Recommendation Report for Planning Permission for Works or Extension to a Dwelling

REF NO: LU/287/19/HH

LOCATION: 34 Tideway
Littlehampton
BN17 6QT

PROPOSAL: First floor side extension

ROOF FLOOR

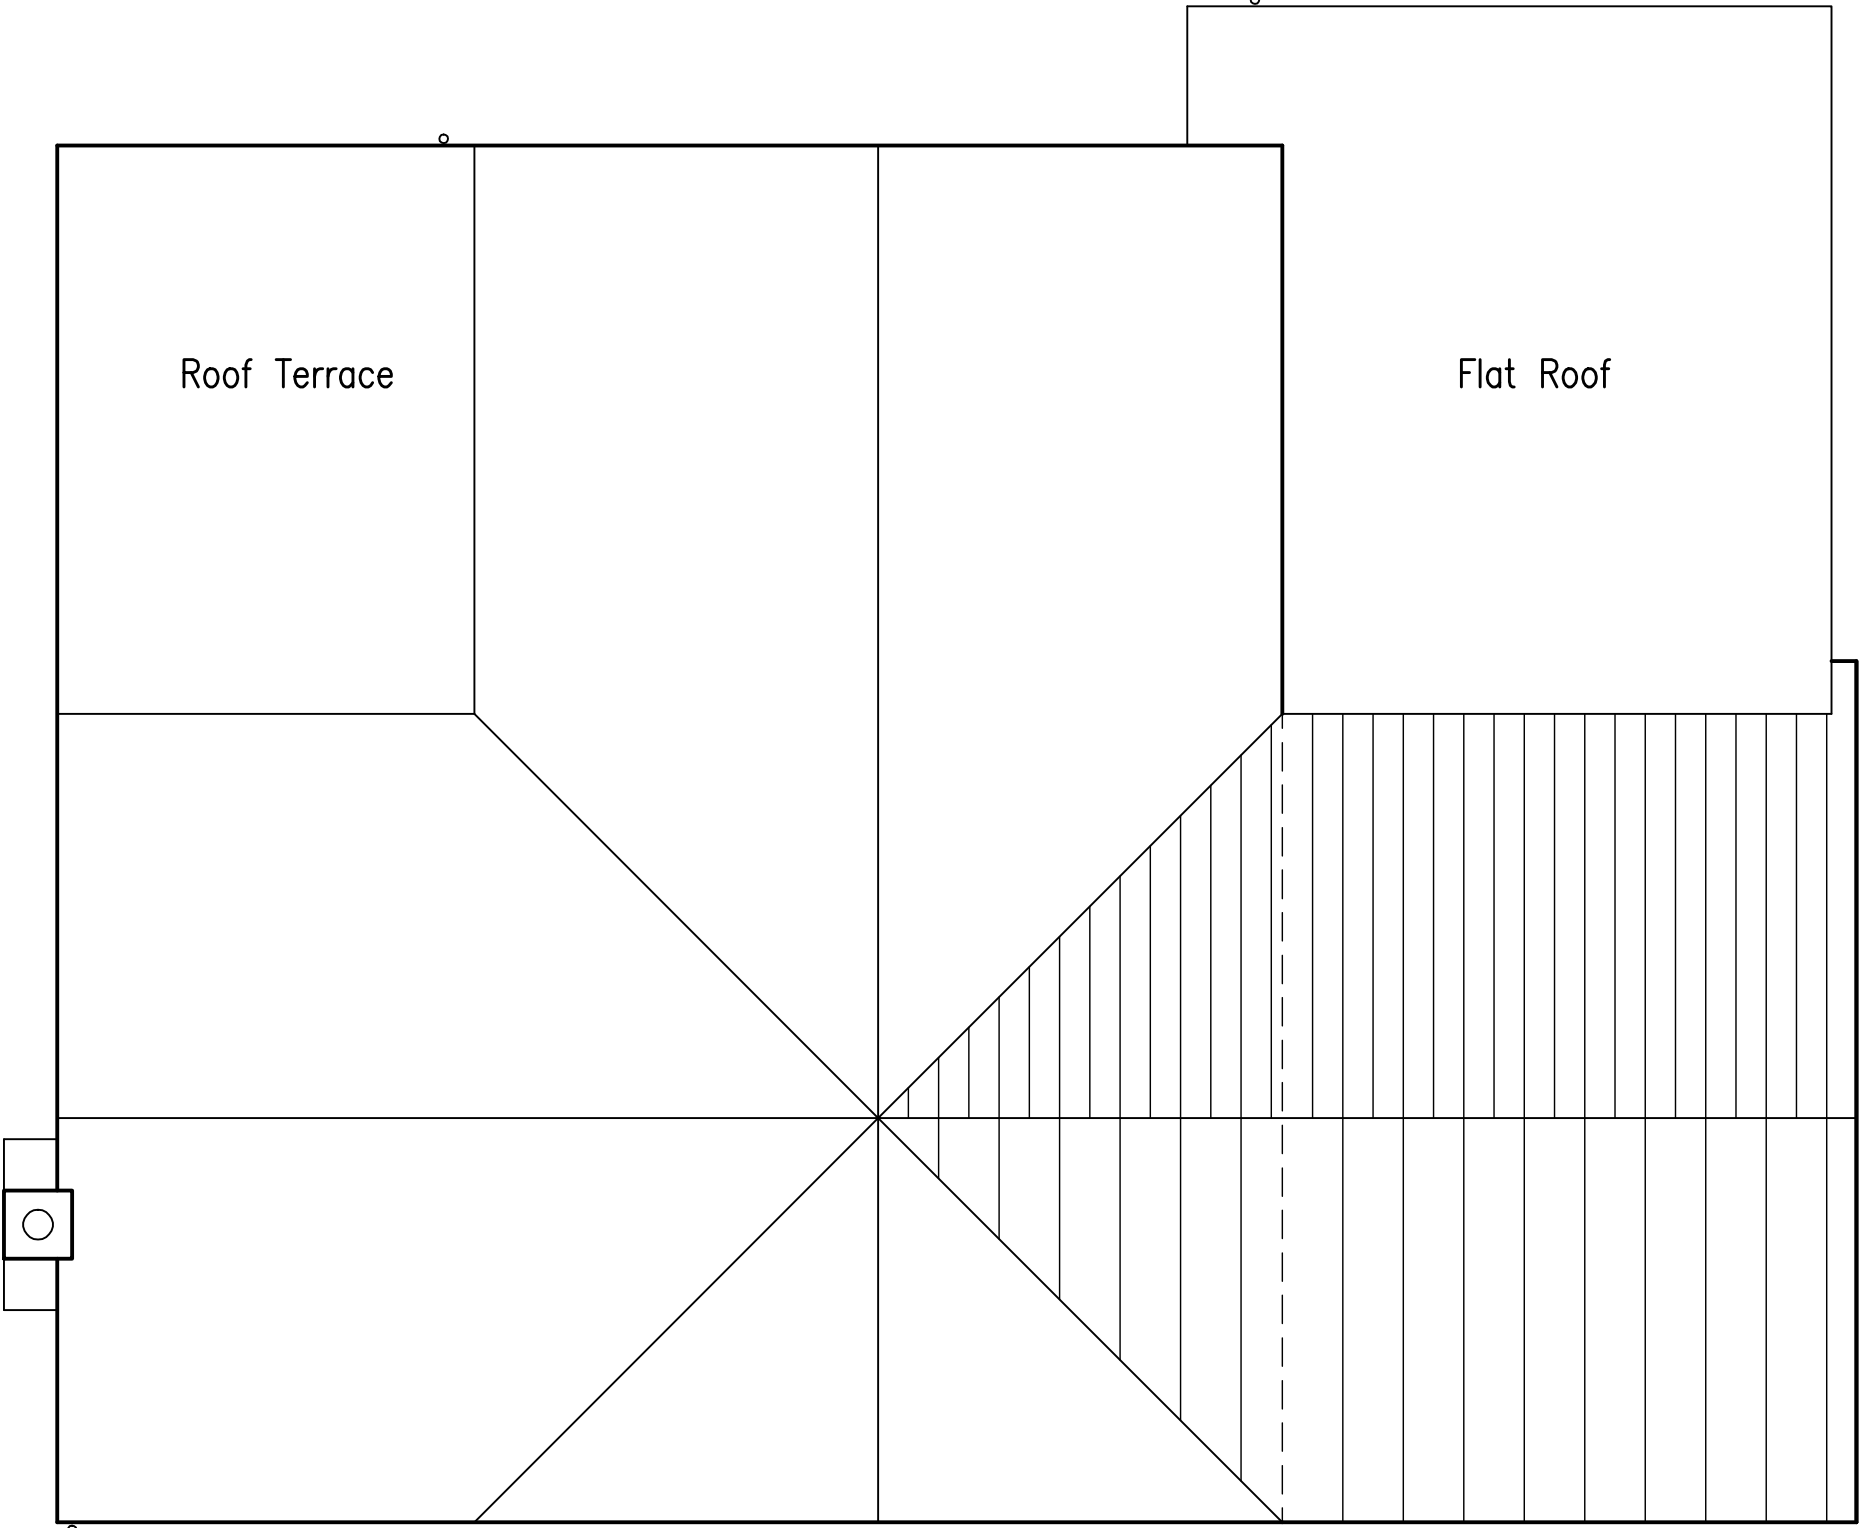
The proposed development is considered to result in a change of appearance of the host dwelling, as a result of the scale of the proposed extension. However, it is not considered to have a significantly detrimental impact on the established character of the host dwelling as a result of its design, scale and use of materials. It would be visually integrated well with the existing dwelling and would result in a sympathetic addition to the dwelling. Therefore, the proposed development is considered to be in accordance with D DM1(2), D DM4(a) and (b) of the Arun Local Plan.

The proposed extension is readily visible from the street scene given its prominent location. This is because the proposed development will not only be visible from the street scene of Tideway, but also Seagate Walk. However, there are other examples of similar side extensions within the location and it is not considered that the changes to this property will harm the spatial pattern of the area given the design of the proposed development, it is also considered to be well integrated with the host dwelling and resultantly, the development is not considered to be visually harmful to the established character of the area or the property. The proposed development is therefore in accordance with D DM1 and D DM4(e) of the Arun Local Plan.

The proposed extension is not considered to give rise to any significantly adverse impact on the neighbouring dwellings. The impact of overlooking from the rear is no worse than that resulting from the existing dwelling, there is 1 proposed window on the side (Northern) elevation of the extension, this is also considered to preserve the existing level of privacy, however due to the location and use a condition has been added to ensure the privacy of the neighbours. The siting of the extension is considered to be ample distance from adjacent dwellings in order to prevent any unacceptable overbearing or overshadowing at adjacent dwellings. Therefore, the proposed development is considered to be in accordance with D DM1(3) and D DM4(c) of the Arun Local Plan.

- 3 The window at the first floor level in the Northern elevation of the building shall at all time be obscurely glazed and non opening up to 1.7m above ground floor level.
